**KIRKLEES METROPOLITAN COUNCIL
INVESTMENT & REGENERATION SERVICE**

DELEGATED DECISION TO DETERMINE PLANNING APPLICATIONS

Reference No:	2022/62/94023/W
Site Address:	6, Siskin Gardens, Netherton, Huddersfield, HD4 7FB
Description:	Erection of single storey rear extension
Recommending Officer:	Laura Yeadon

BLOCK PLAN

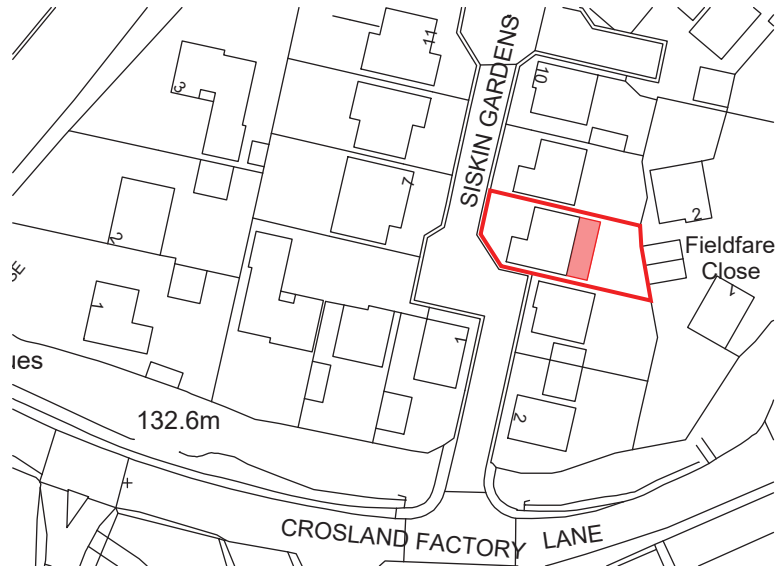
Key Design Principle 7 requires that extensions should ensure that appropriately sized and useable areas of outdoor space is retained and in this instance, due to the extent of curtilage and as demonstrated on the submitted block plan, the works are not considered to result in an overdevelopment of the site as a usable garden space would remain. The works would be within the confines of the existing residential curtilage. The development is therefore considered to comply with this principle.

In terms of the impact on neighbouring properties, No. 4 is located to the south of the application site and is set significantly back from the application site and the submitted block plan indicates that there would be little impact on this property in terms of overshadowing. There are no proposed openings within the side elevation of this property that would create harm from overlooking.

client	MR MIDDLEBROOK		
project	PROPOSED REAR EXTENSION 6 SISKIN GARDENS NETHERTON HUDDERSFIELD, HD4 7FB		
drawing	PROPOSED PLANS		
revision	notes	date	drawn
*	*	*	*
scale :	1:50 AT A1	09.22	PB
project no.	2239	drawing no.	02

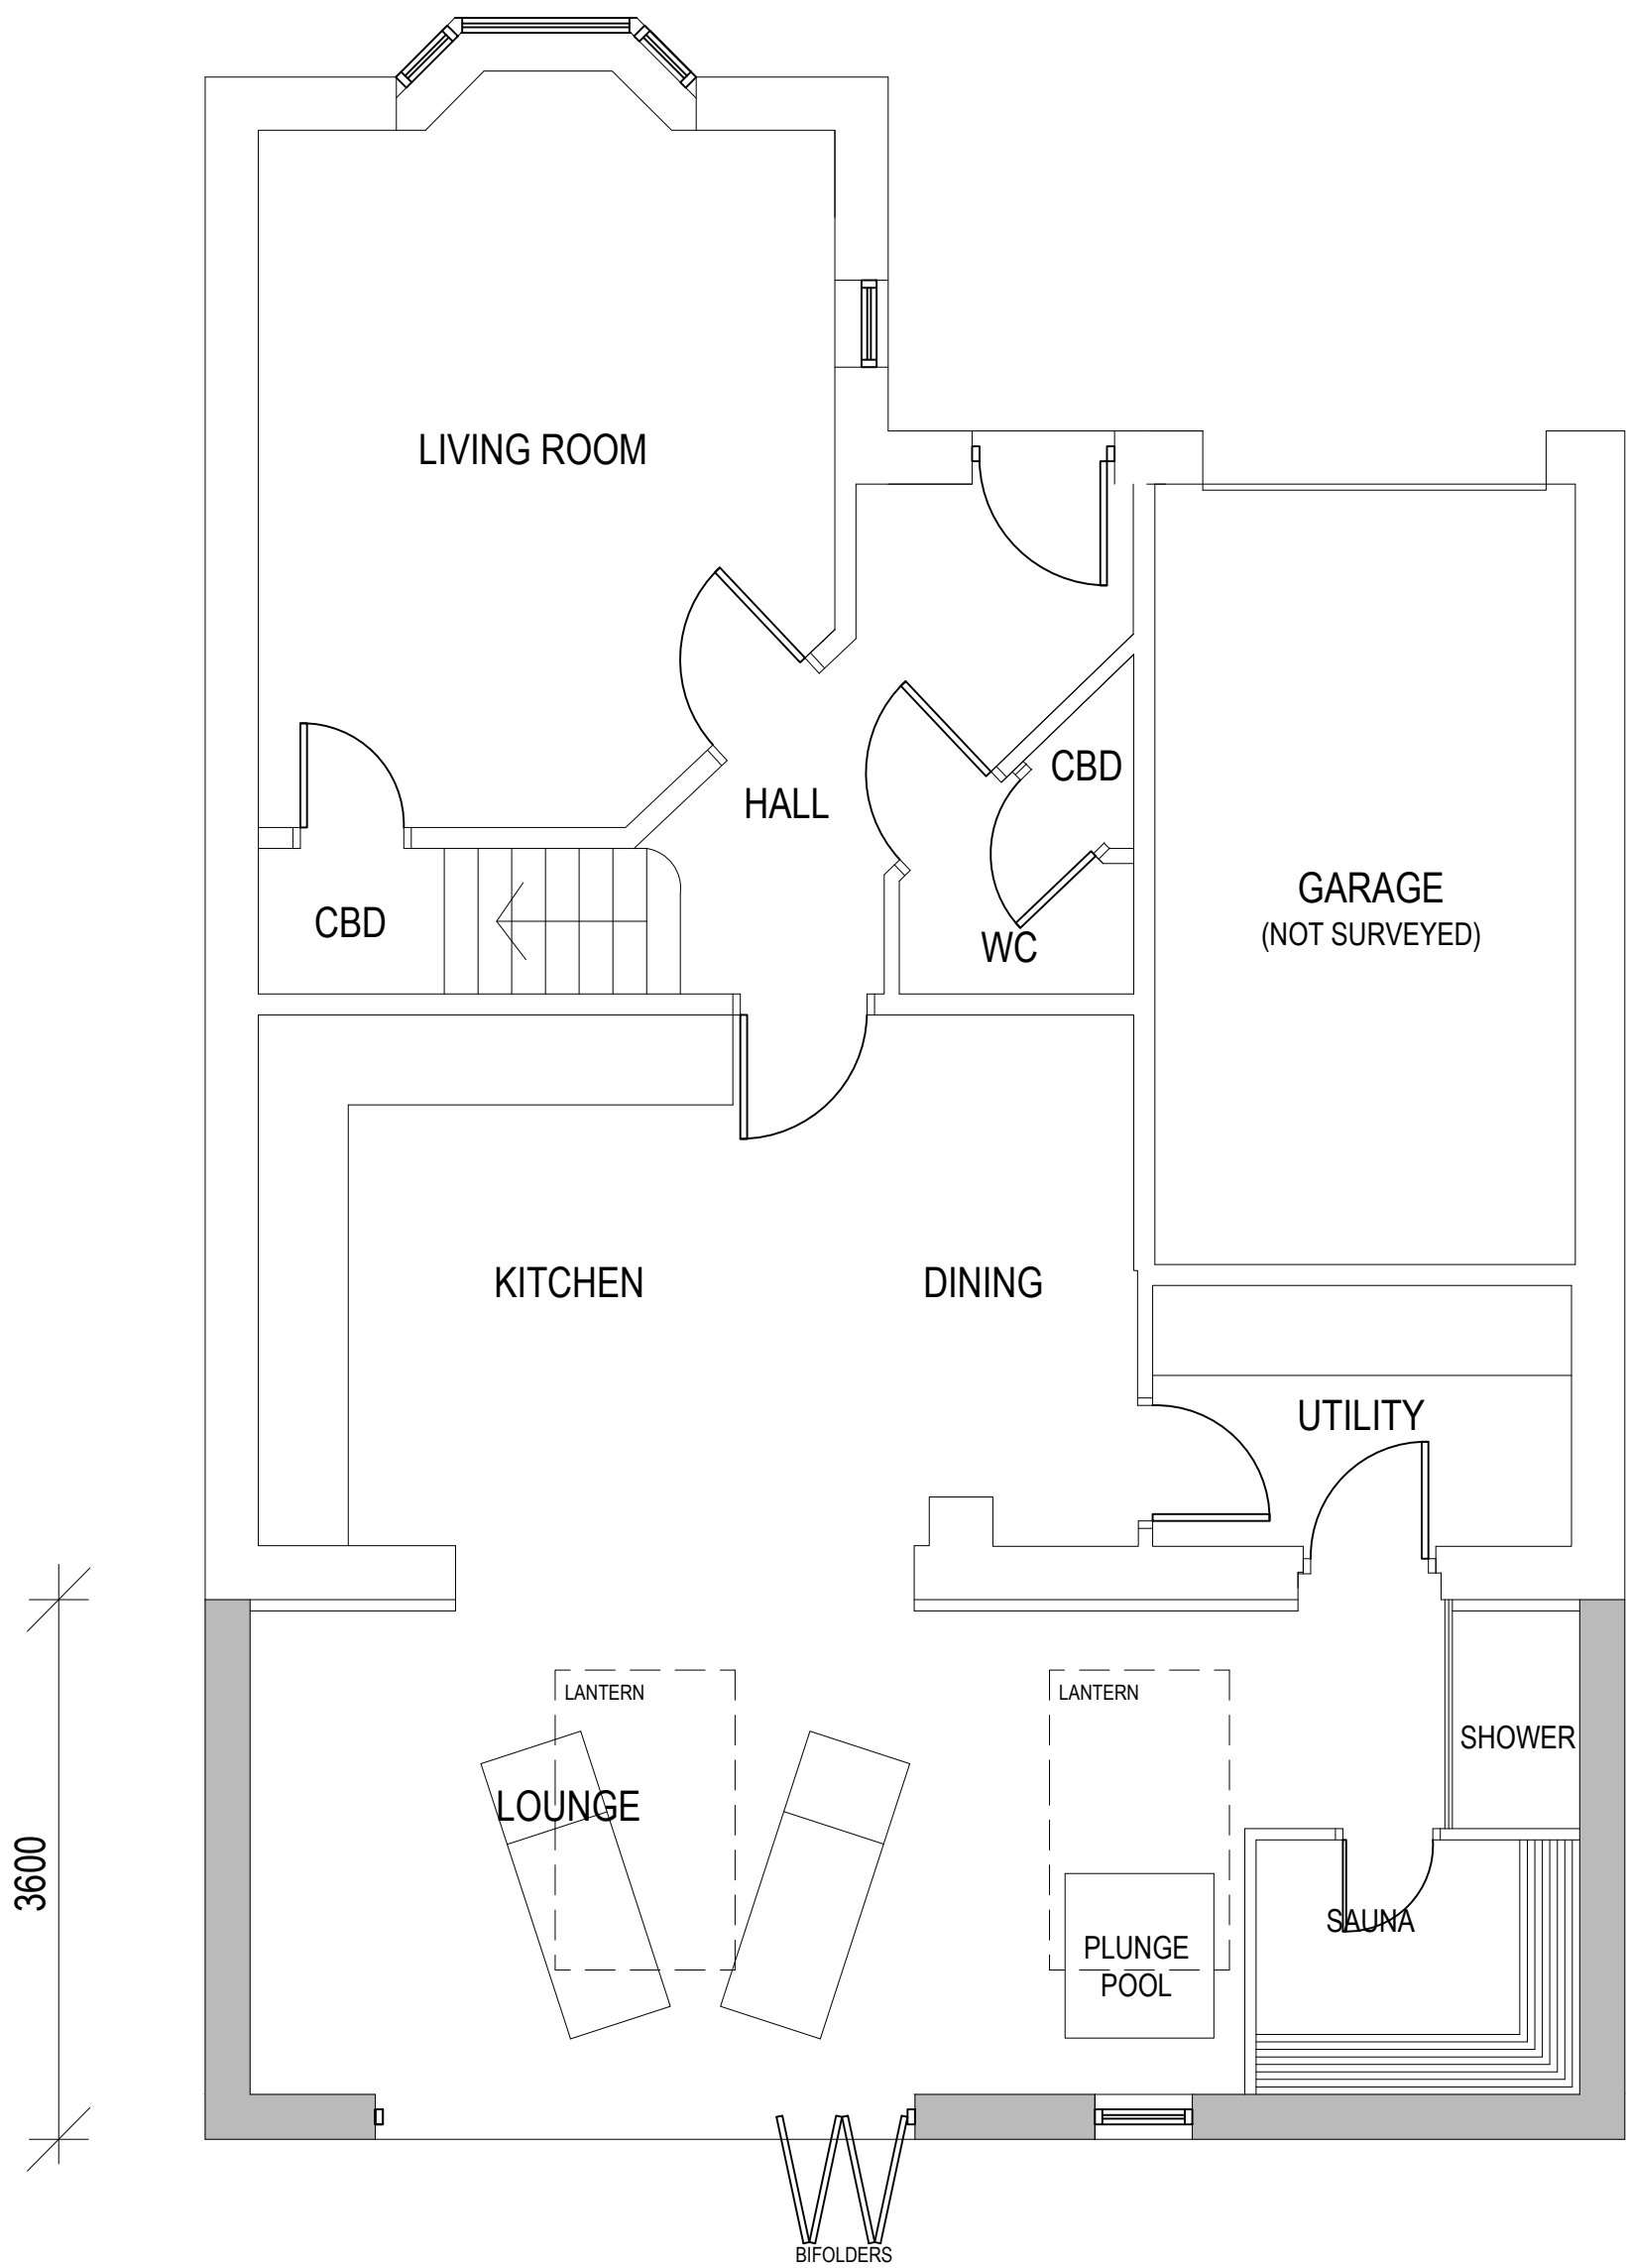
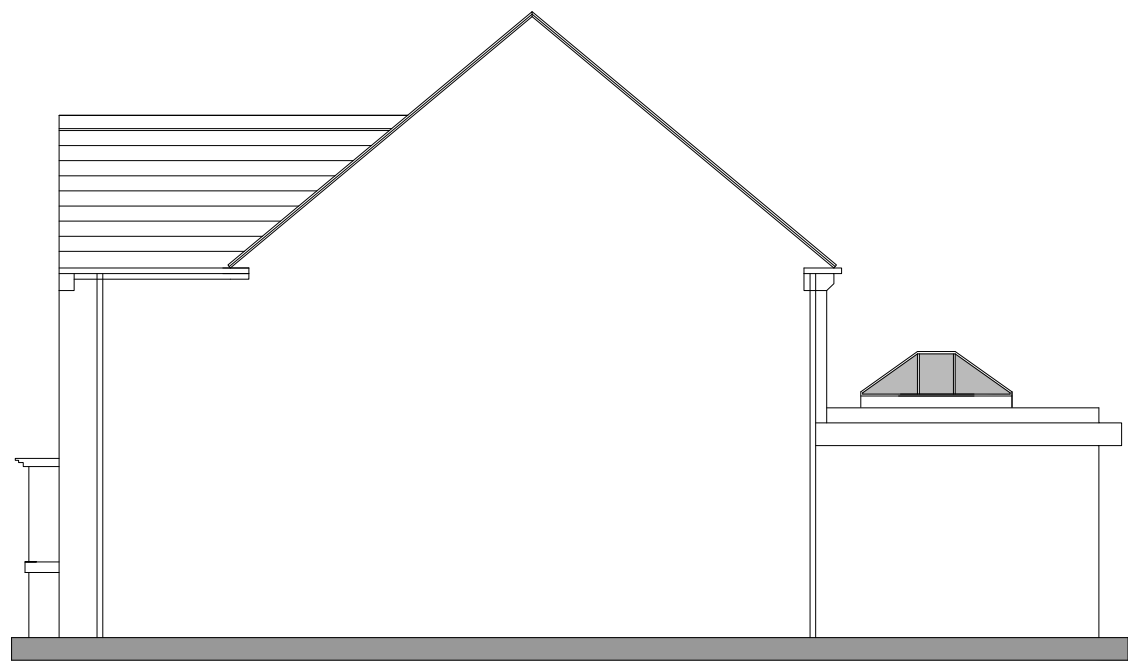
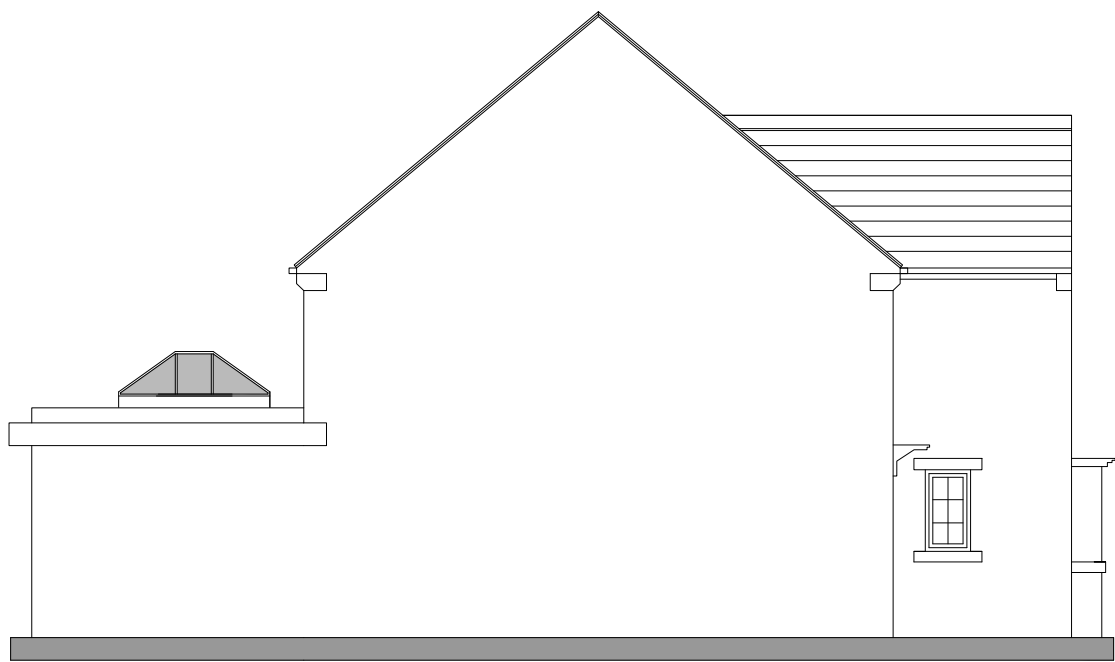
Whilst the extension would not be set in from the shared boundaries by a minimum of 1m, the extension would lie flush with the existing side elevations of the host property. Due to being single storey, in terms of the visual appearance, would be subservient to the host dwelling and would not detract from its character, in accordance with Key Design Principle 2 of the SPD.

In terms of the impact on No. 8, the proposed extension would be located to the south of this dwelling and due to No. 8 being set slightly further west than the host property, there would be a level of impact from the proposal. The separation distance between the side of the host property and side of no.8 is 1.8m

Key design principle 5 of the SPD recommends that the 45-degree rule should be treated as a starting point in assessing impact for all extensions, i.e. a line drawn from the midpoint in the nearest adjacent habitable room window at an angle of 45 degrees should preferably not intersect the extension. In this instance it is not considered that the 45-degree rule would be met due to the staggered formation of the site layout. However, as stated above, the extension (subject to conditions) could be constructed without the requirement of Planning Permission. Furthermore, whilst the 45 degree line would be cut, this would be marginal.

The impact of the proposal, taking account of its size, scale, level of projection from the rear of the host property (3.6m) and also separation distance from no.8 is not considered to be of such significance in relation to overshadowing or overbearing impact which would warrant refusal by the LPA in this case.
